Application no: **3/2023/0960**

Address: **Hough Clough Barn Houghclough Lane Chipping PR3 2NT**

Proposal: **Regularisation of change of use of games room to holiday let.**

The Local Highway Authority have viewed the plans and highway related documents and have the following comments to make:

ACCESS TO HOUGHCLOUGH LANE

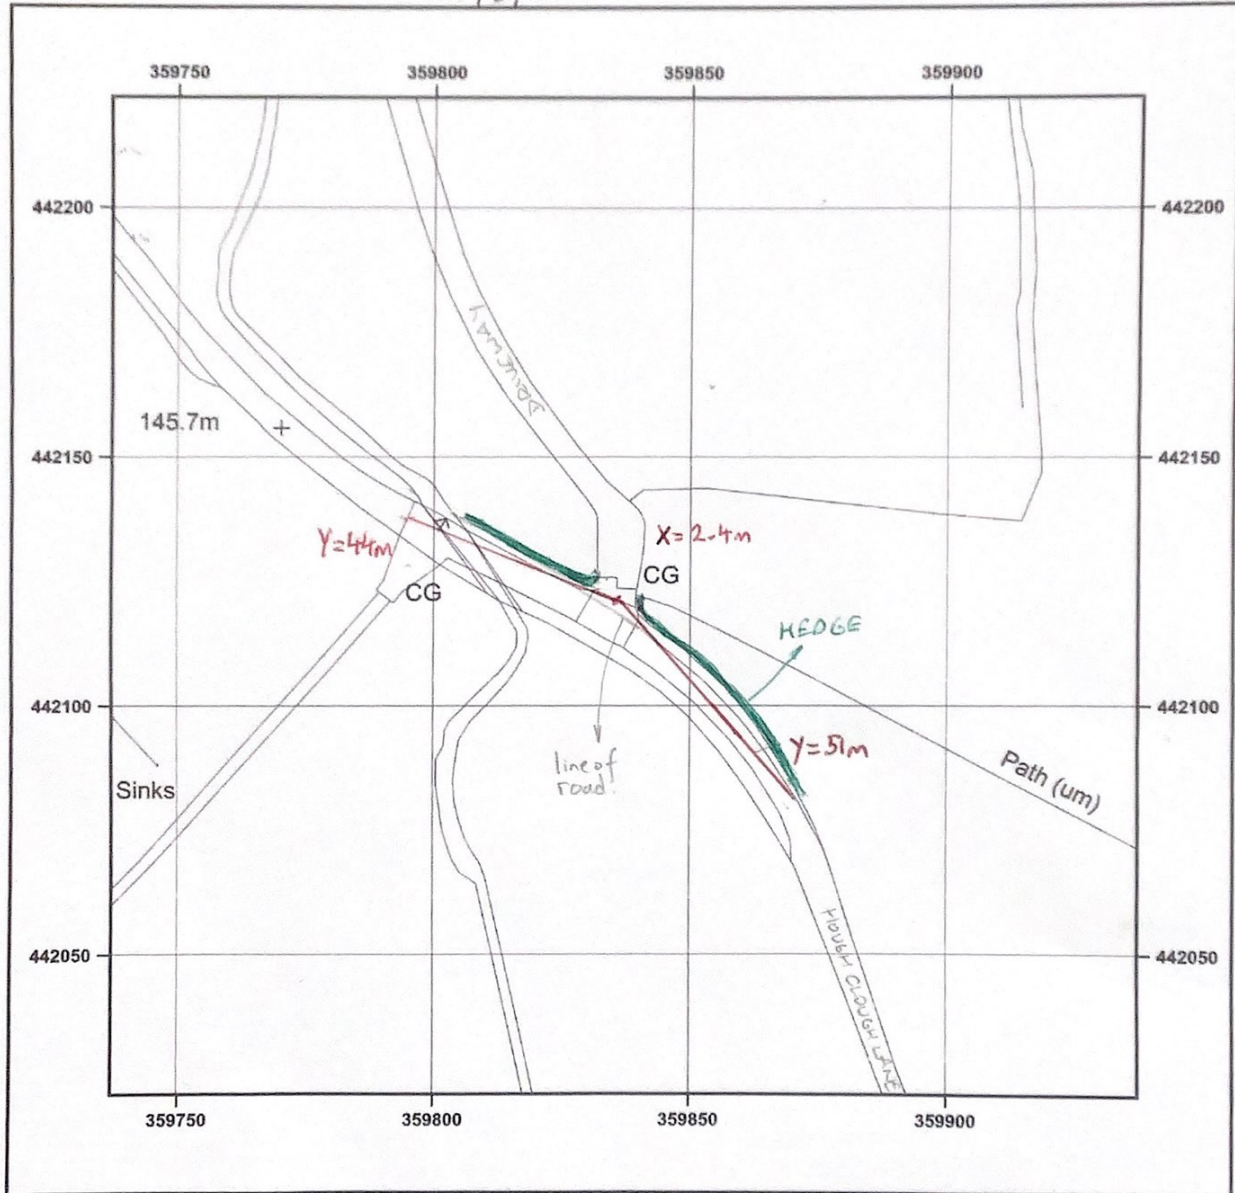
The LHA are aware that a traffic survey was conducted within the vicinity of the site on 19th-25th February 2025. The traffic survey found that 85th percentile speeds along Houghclough Lane were 30.8mph northwestbound and 33.9mph southeastbound. As a result of these results, the Applicant has provided drawing titled "Access to Houghclough Lane Visibility Splays. Revised." Dated 27th March 2024, which shows that the existing access can provide visibility splays of 2.4m x 44m to the west and 51m to the east. The values of these visibility splays comply with the LHAs visibility splay guidance and so the LHA are satisfied that the access has adequate visibility following the intensification of use of the access.

The LHA have also further reviewed the drawing titled "Access to Houghclough Lane Visibility Splays. Revised." Dated 27th March 2024 and have no comments to make regarding the access width.

1. No part of the development hereby permitted shall be occupied until such time as vehicular visibility splays of 2.4 metres by 44 metres to the west and 2.4 metres by 51 metres to the east have been provided at the site access. These shall thereafter be permanently maintained with nothing within those splays higher than 1 metres above the level of the adjacent footway/verge/highway.

AMENDED SITE PLAN 25/2/24.

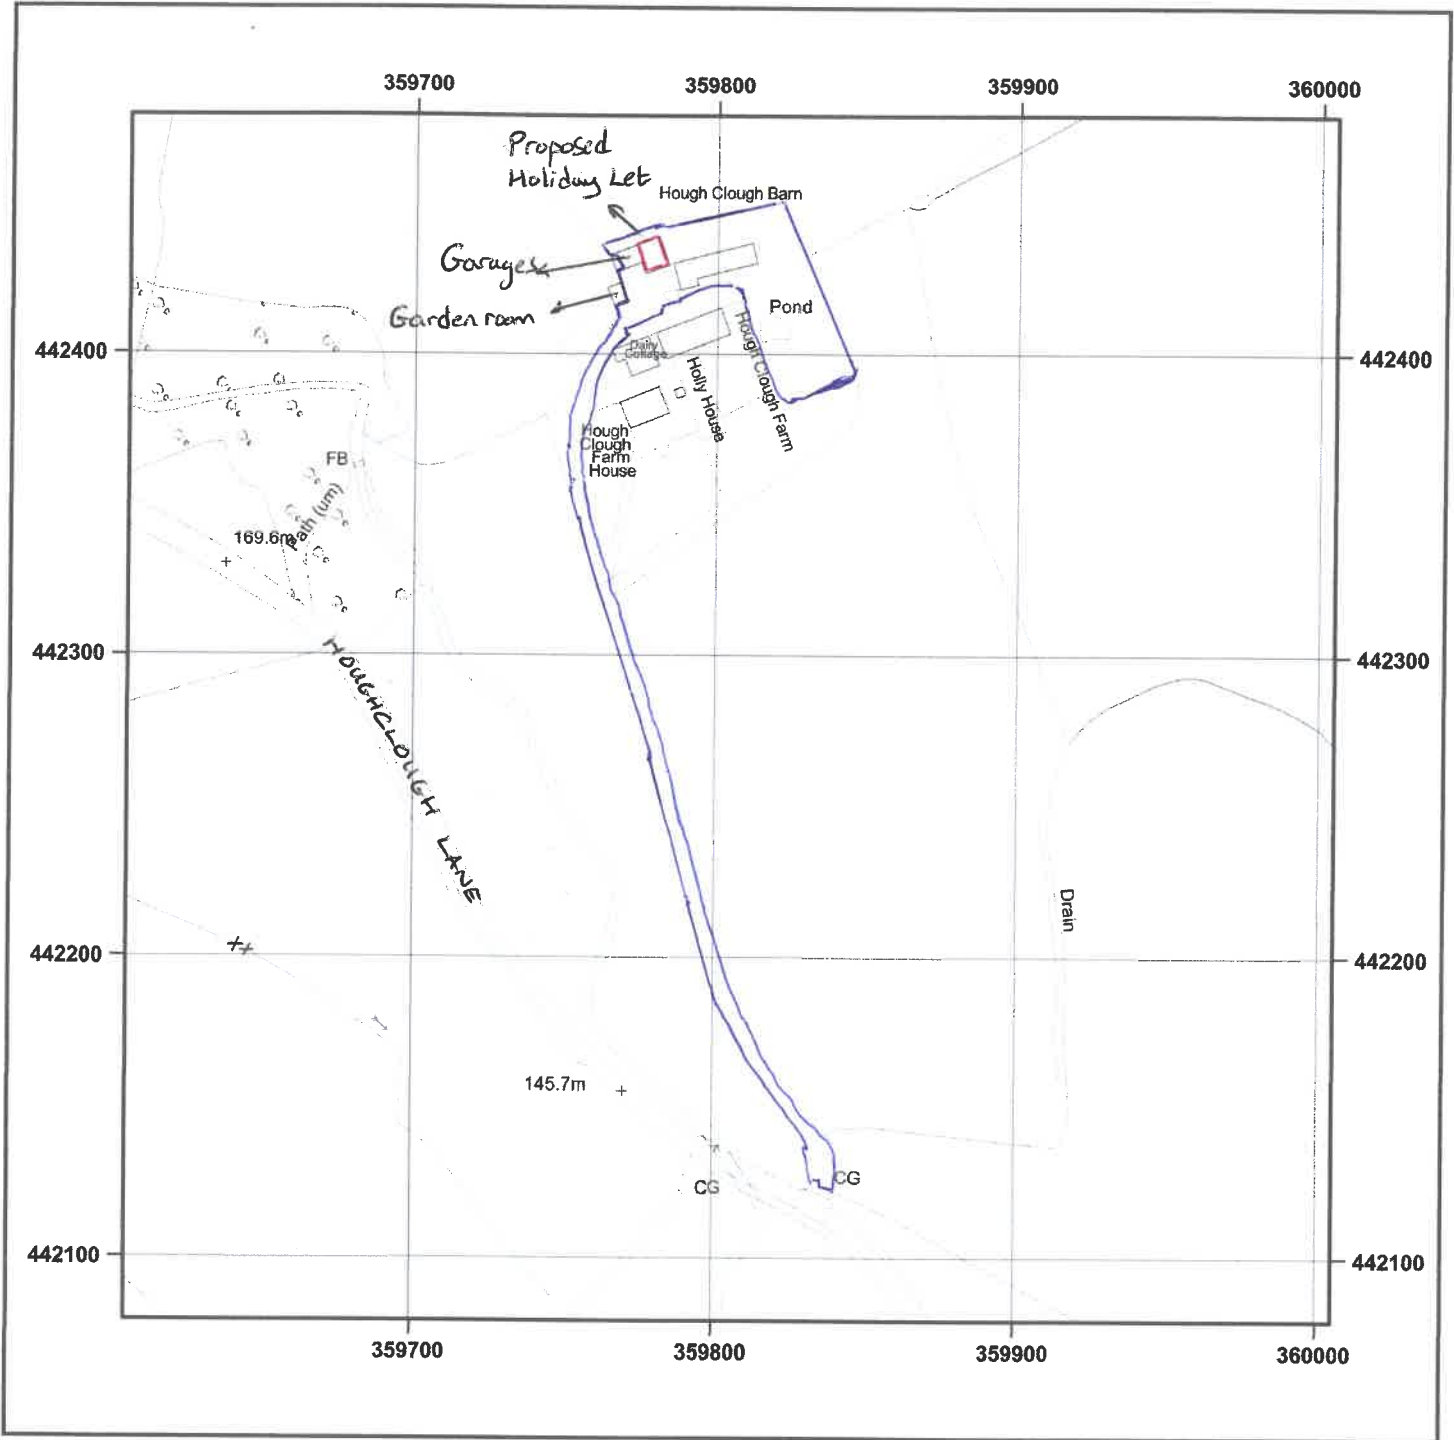
The LHA have reviewed the drawing titled "Parking Plan" dated 29th February 2024 and are aware that the site has adequate parking facilities for the existing dwelling and the proposed holiday let. These parking spaces will not interfere with the Public Rights of Way which run through the site and the Applicant will be able to privately manage this area. Therefore, the LHA have no further comments to make.
